## MMC Office Building Final Traffic Comments

Hi Nell – The following is a status update on prior comments and represent Final Traffic Comments. I have separated the comments that are associated with issuance of a Traffic Movement Permit.

CONSTRUCTION MANAGEMENT PLAN
UPDATED [11-05-18]

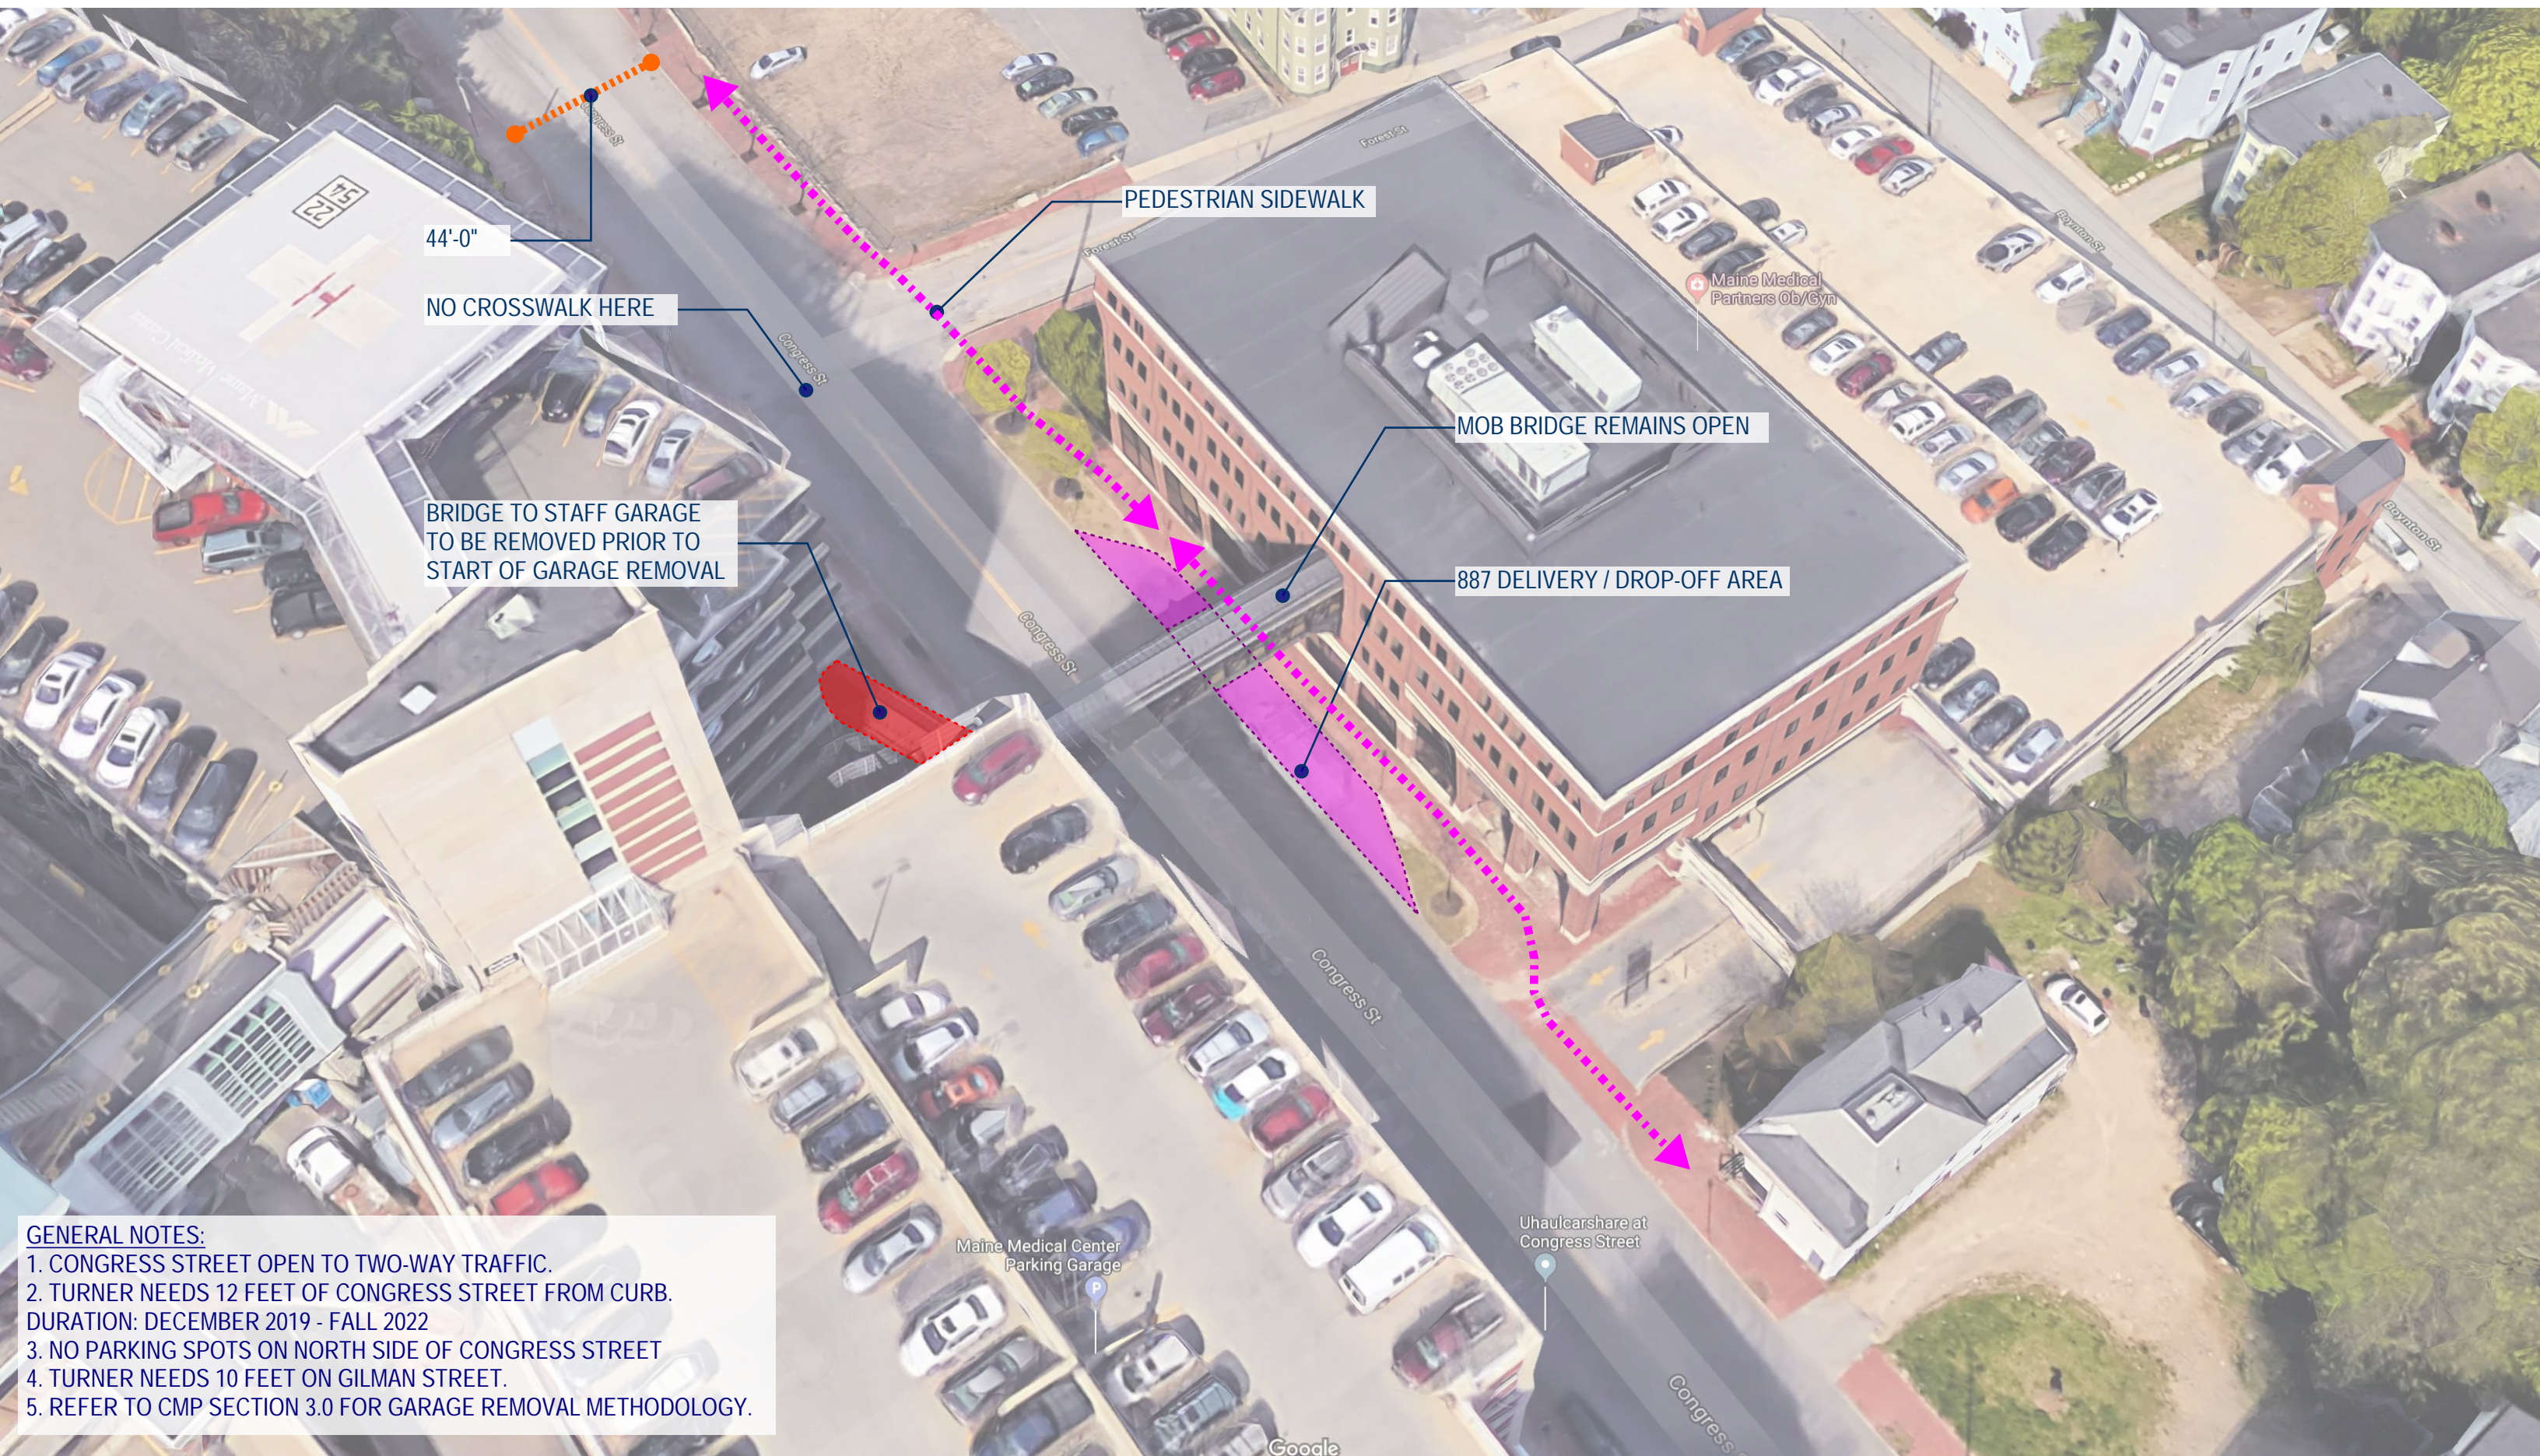
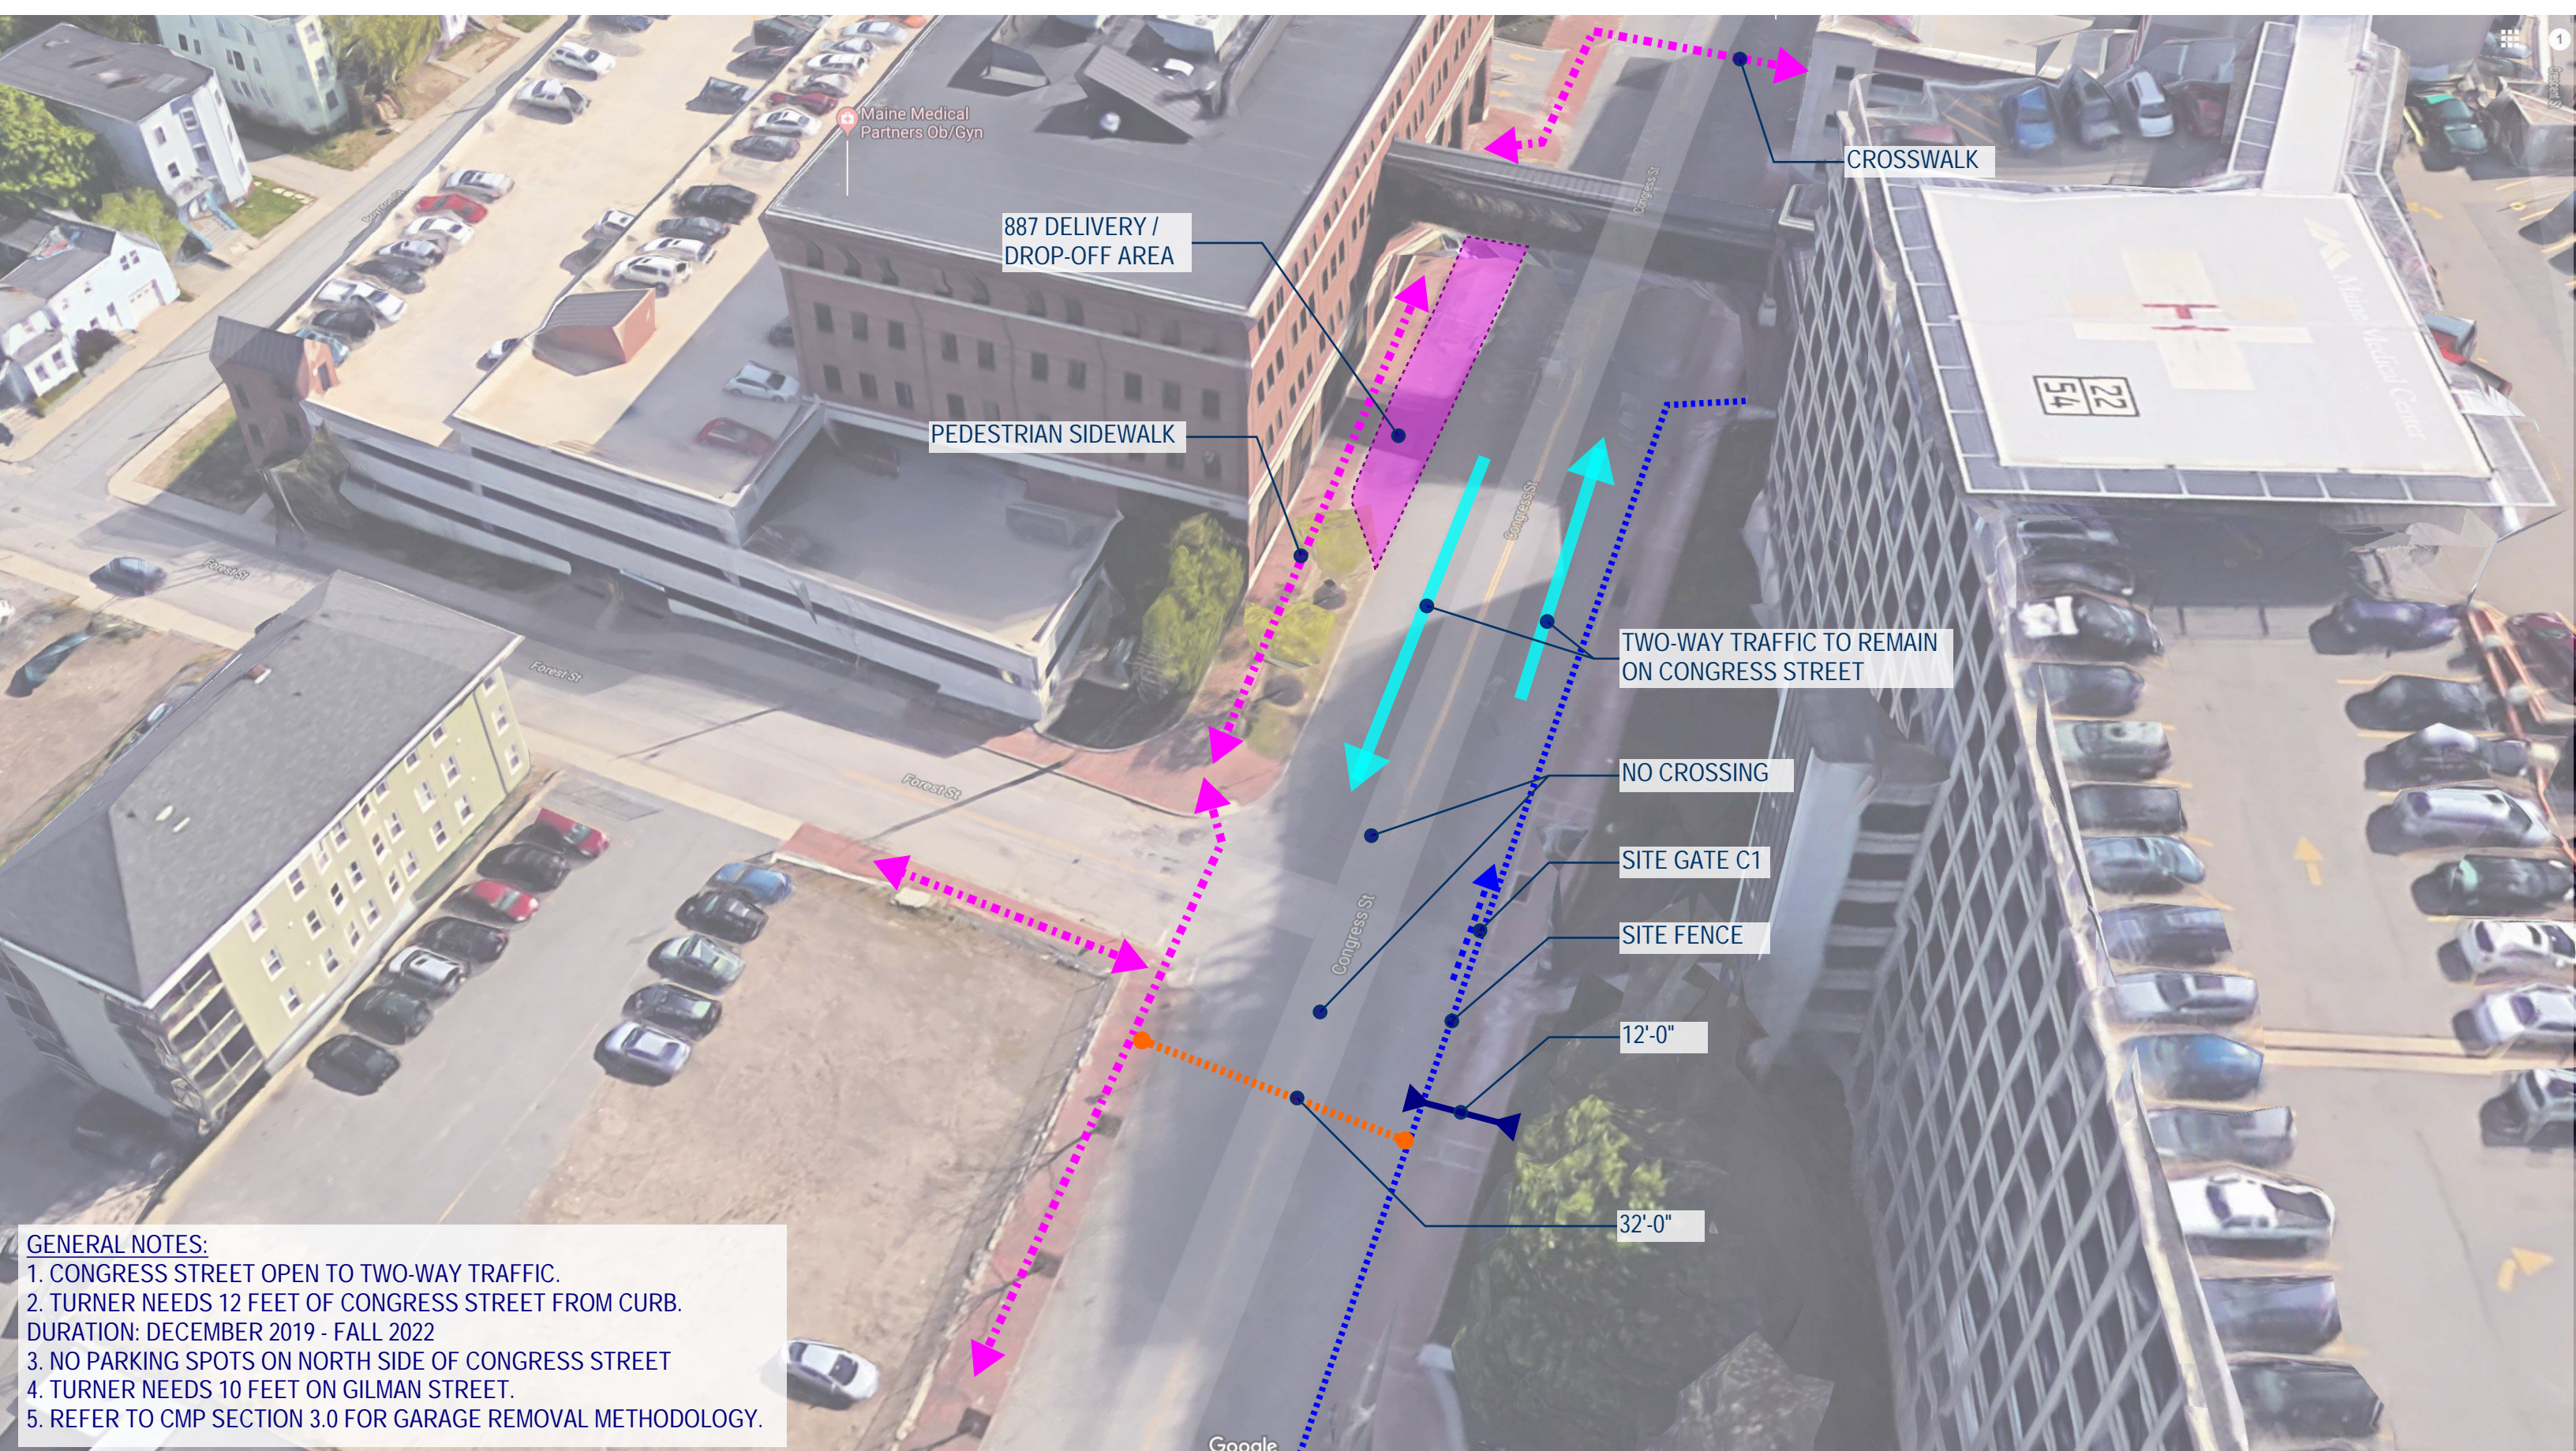
- **I have reviewed the Construction Management Plan and generally find it to be acceptable. Some specific comments:**
  - **It is recommended that further discussion on the duration of the Congress Street sidewalk closures be included.**
  - **Supplemental pedestrian safety devices will be required during the sidewalk closure time period (to safely cross pedestrians for the sidewalk detour).**
  - **All sidewalk detours shall be ADA compliant.**
  - **Changes to the lane configuration on Congress Street west of Gilman Street is likely and may need to be included in the plan.**
  - **A significant amount of construction activity will be required for utility and street construction work and specific plans shall be development for review and approval.**
